RE: Jersey Mike's Subs
1624 NC 24-87 Hwy
Cameron, NC 28326

This letter acknowledges review of the plan for the above referenced establishment. The revised plans dated 01/25/22, email correspondence and specifications are approved with the following conditions:

A-103
SHEET 3 OF 10

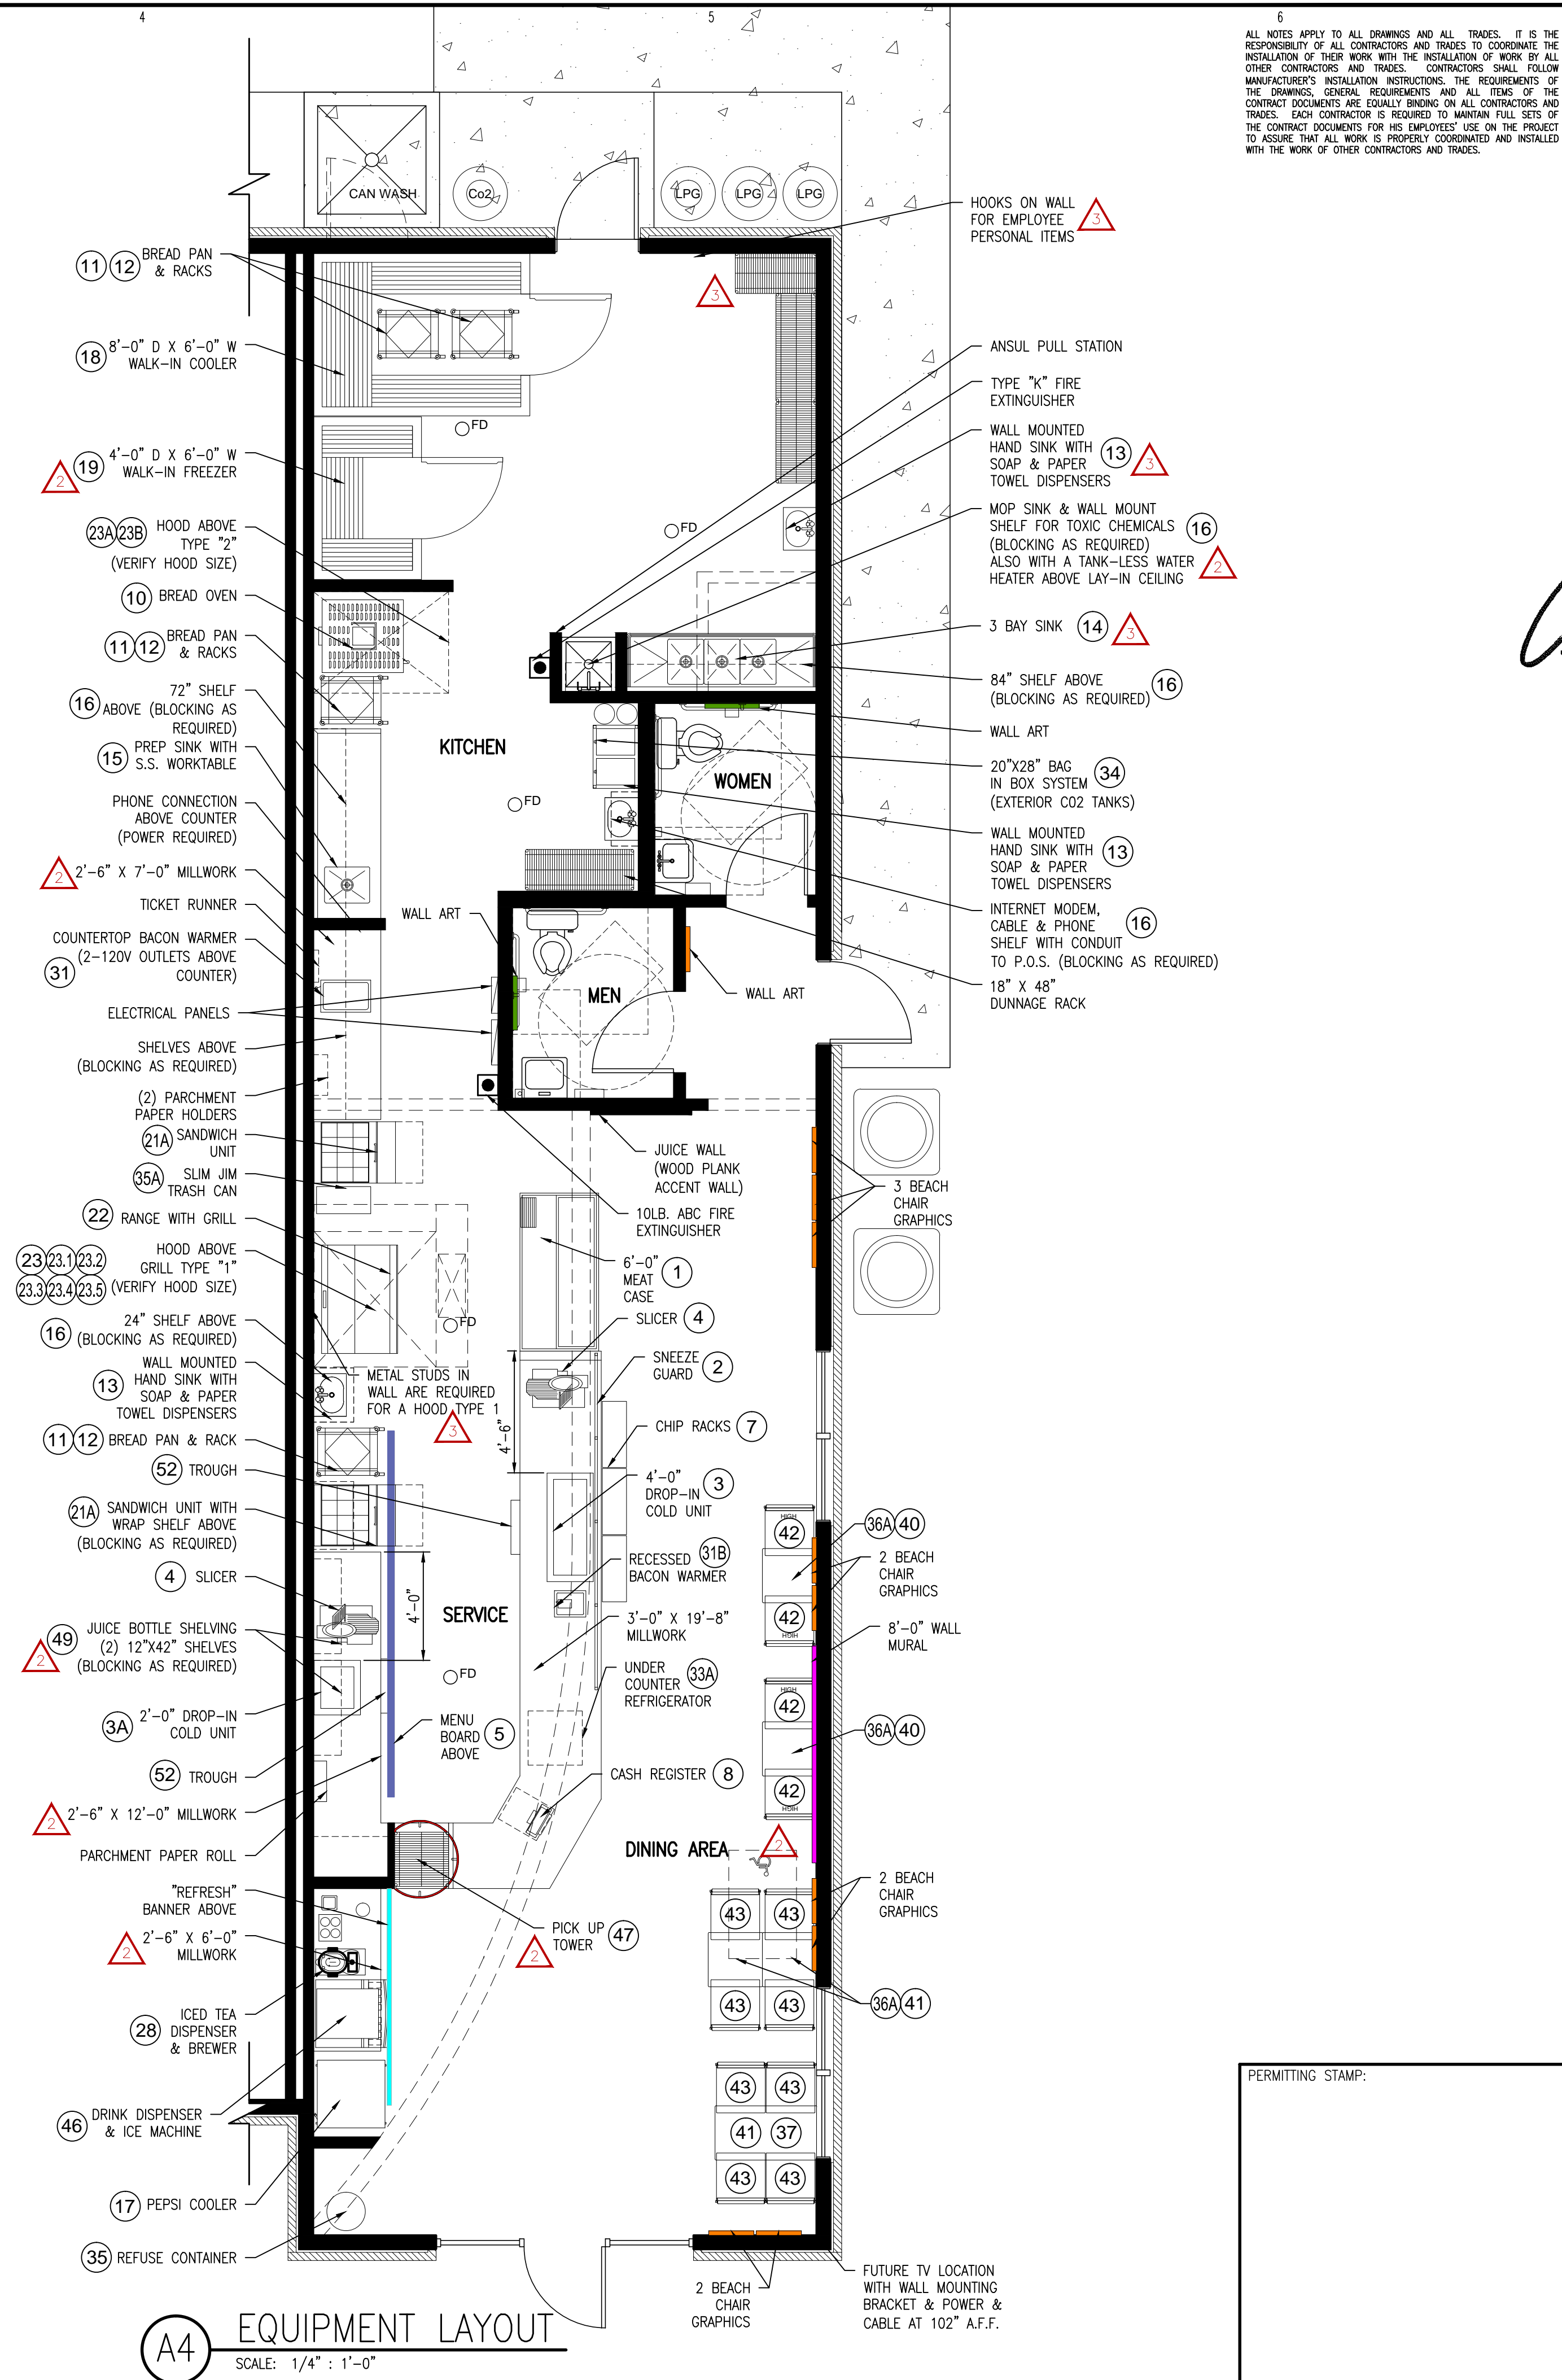
2. The equipment plans and schedule A-103 revised 01/25/22 is approved with the following considerations:
 - a. All food equipment, custom equipment, shelves, counters, and cabinetry must comply with subpart 4-205 of the North Carolina Food Code and be installed as specified in Sections 4-402.11 and 4-402.12 of the Code.

- b. The sneeze guard(s) will be installed 5' at finished floor,
 - c. Splash guard(s) are to be installed on hand wash sinks where splash contamination from handwashing is a concern.

- d. Employee lockers/coat hooks are to be provided for employee storage of personal items and the location will comply with Code.
 - e. Revised plans include additional hand wash sink with soap and towels located in the rear 3-compartment area for a total of 3 hand wash sinks. The number shown on the application is incorrect.

P1
 SHEET OF

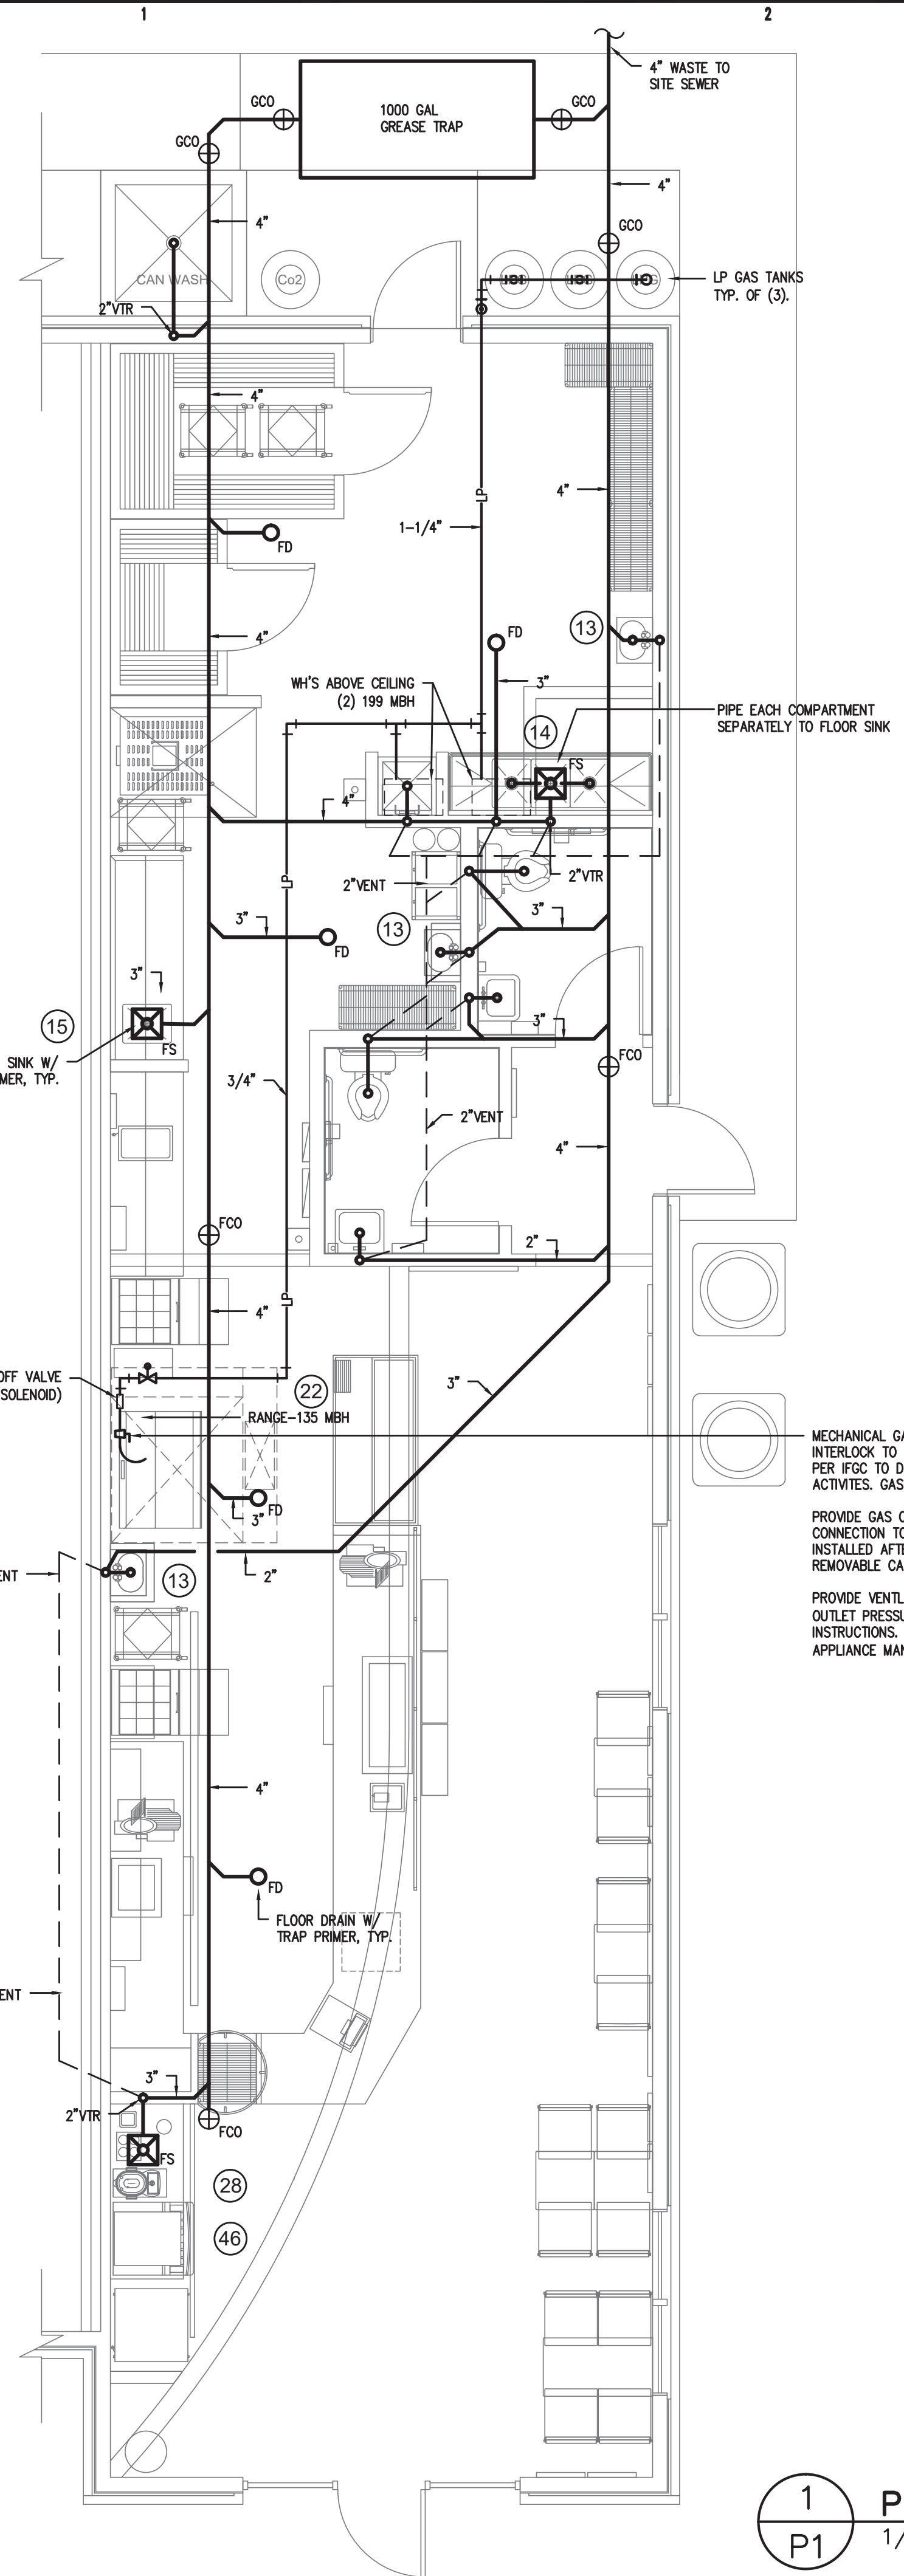
4. The plumbing water and waste plans must comply with Parts 5-1 and 5-2 and Parts 6-1, 6-4 and 6-5 of the NC Food Code. The two 199,000 BTU tankless water heaters specified on plan sheets A-103, P1 and P2 are approved.
